Site Development Plan - Comment Response Letter

Citizen on Constitution
El Paso County, Colorado

PCD File Number: PPR-2229

SITE DEVELOPMENT PLAN – COMMENT RESPONSE

COURTYARD ENLARGEMENT

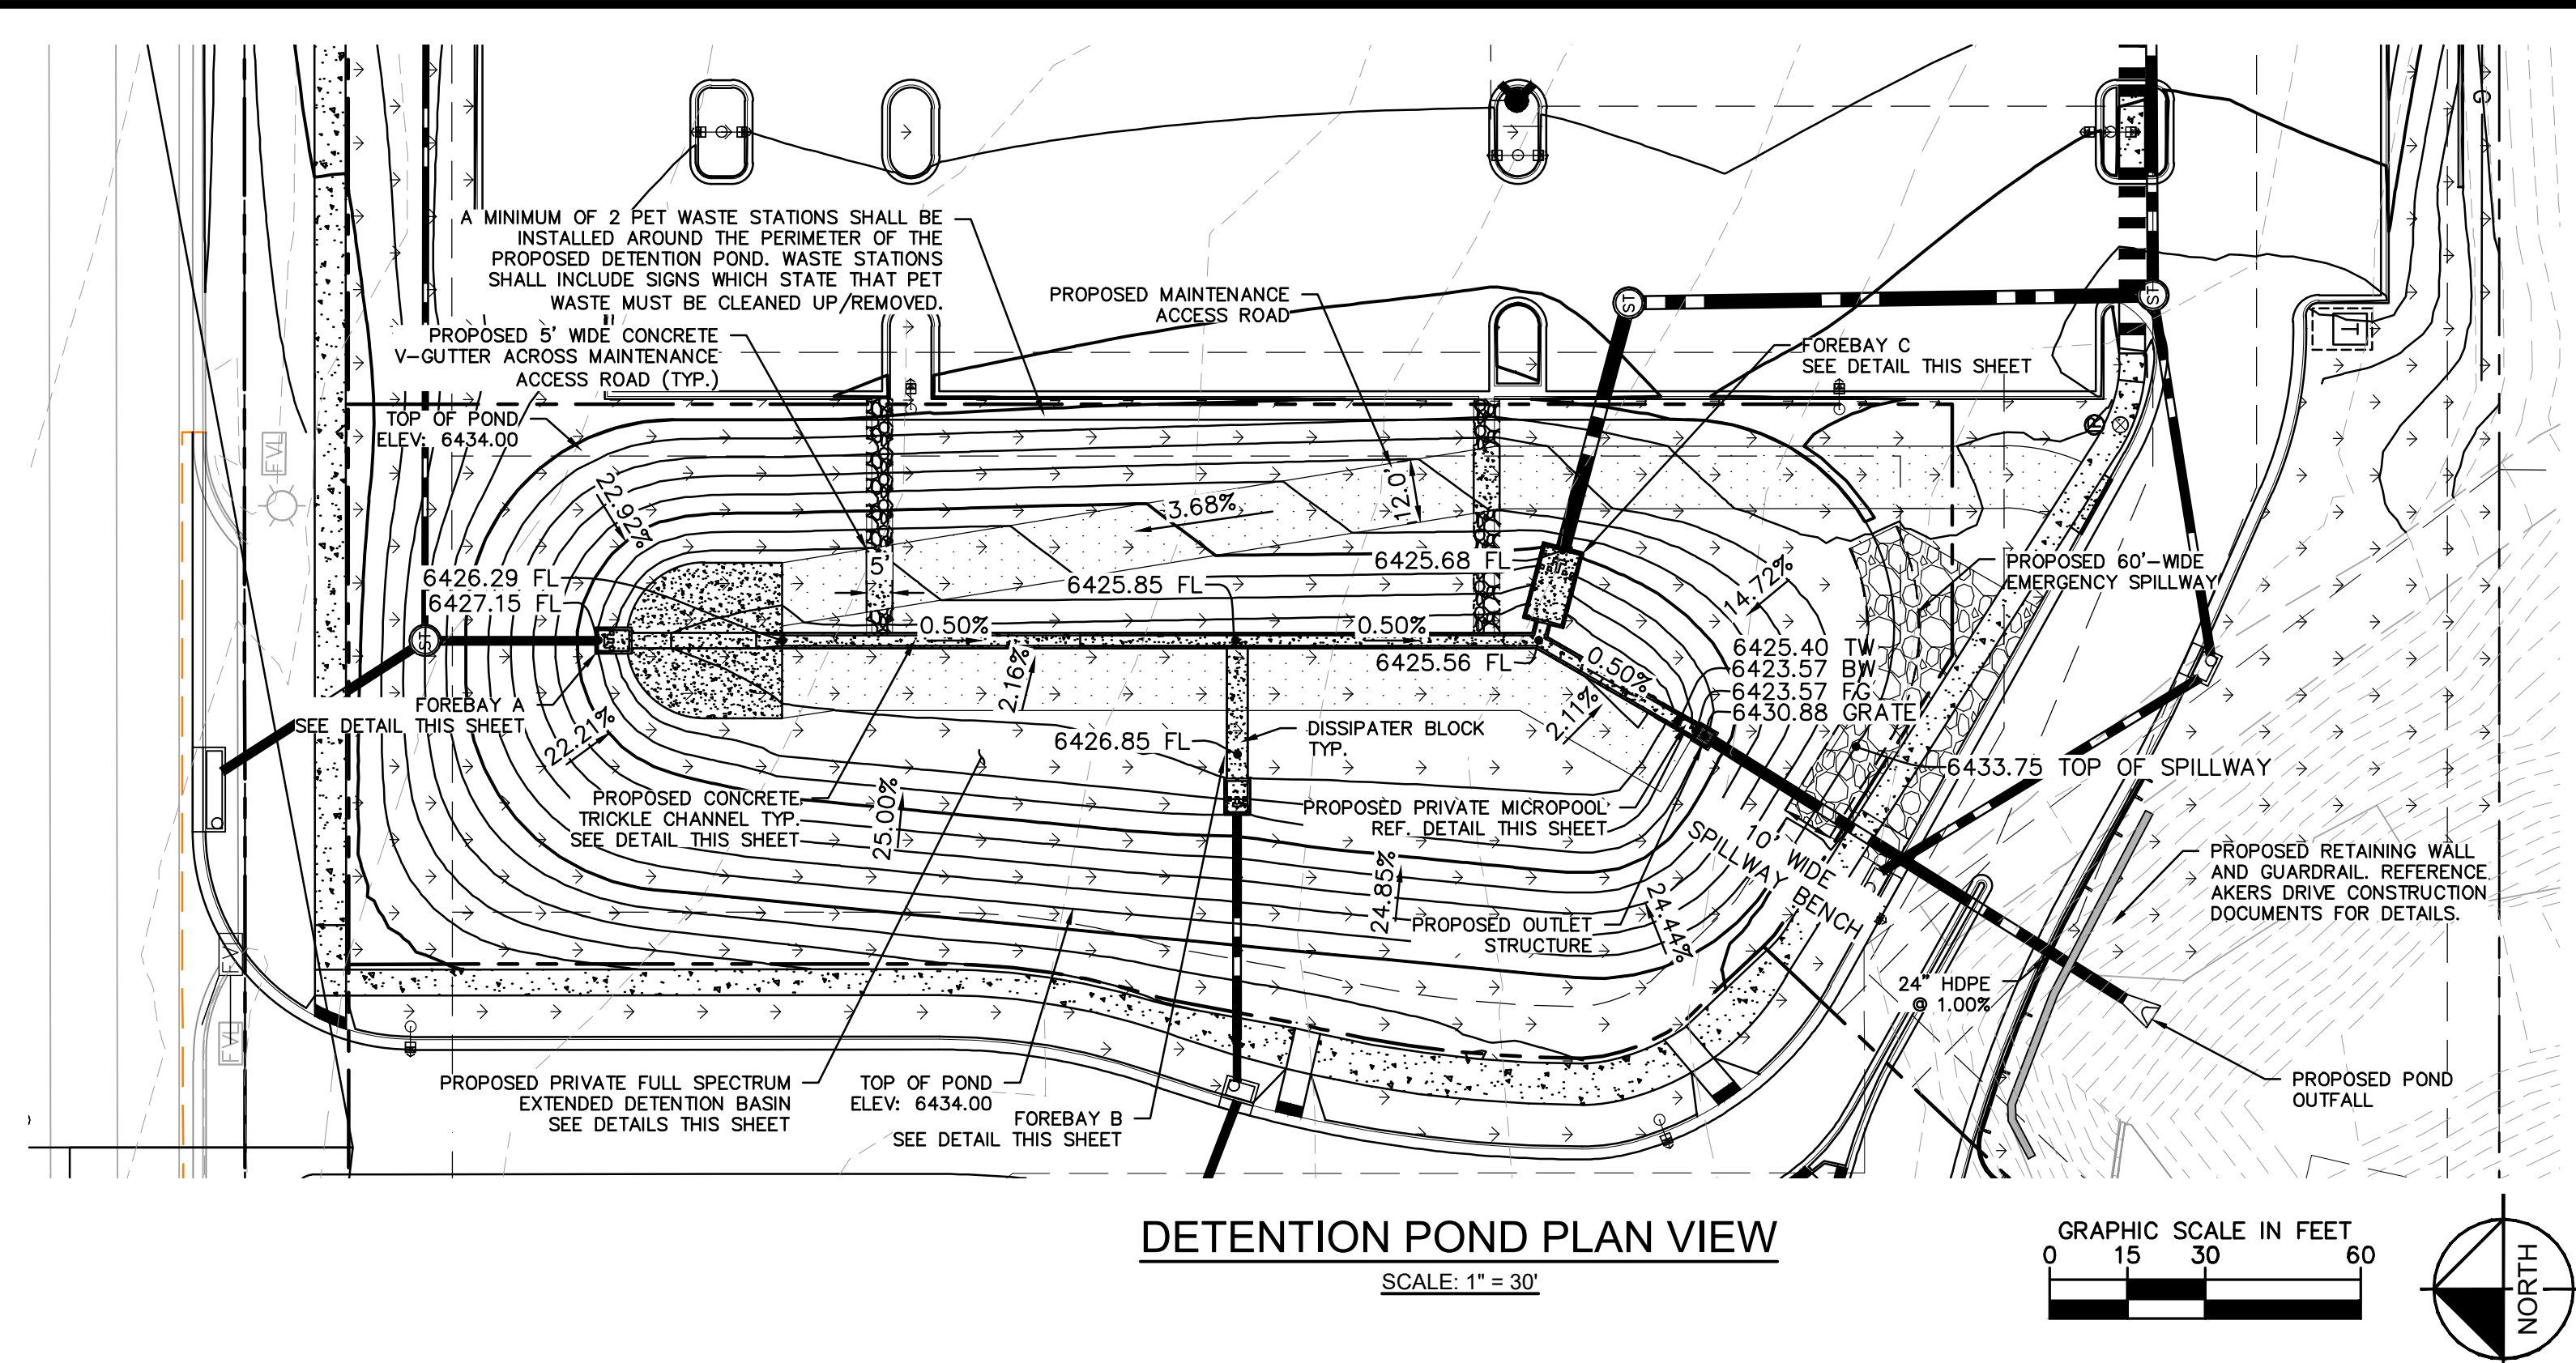
North is actually to the left on this plan drawing.

Pdf pg 117 of FDR shows this as 1.55 sq in. Revise to remove discrepancy.

Does not match what is show in calcs on pdf pg 117 of FDR.

Should be 6030.17 per FDR calcs on pg 117.

Should be 6432.27 per FDR calcs on pg 117

Consider adding a not to have control joints every ~10ft.

Include callout for pet waste station(s) around the pond, with signage stating that pet waste must be picked up.

Sht C4.13 shows front edge and side length to each by 4ft. Revise.

does not match what is shown on Sht C4.13

Thank you. North arrow has been corrected.

Orifice sizes and locations have been revised.

FDR calcs have been revised to match these dimensions.

WSE have been revised to match the current FDR

Elevations have been revised to match the current FDR

Control joint note has been added.

A note, requiring a min. of 2 pet waste stations and required signs has been added to this sheet.

Front edge has been corrected. The 2nd value should be 12 as it is the combination of the three sides that receive stormwater).
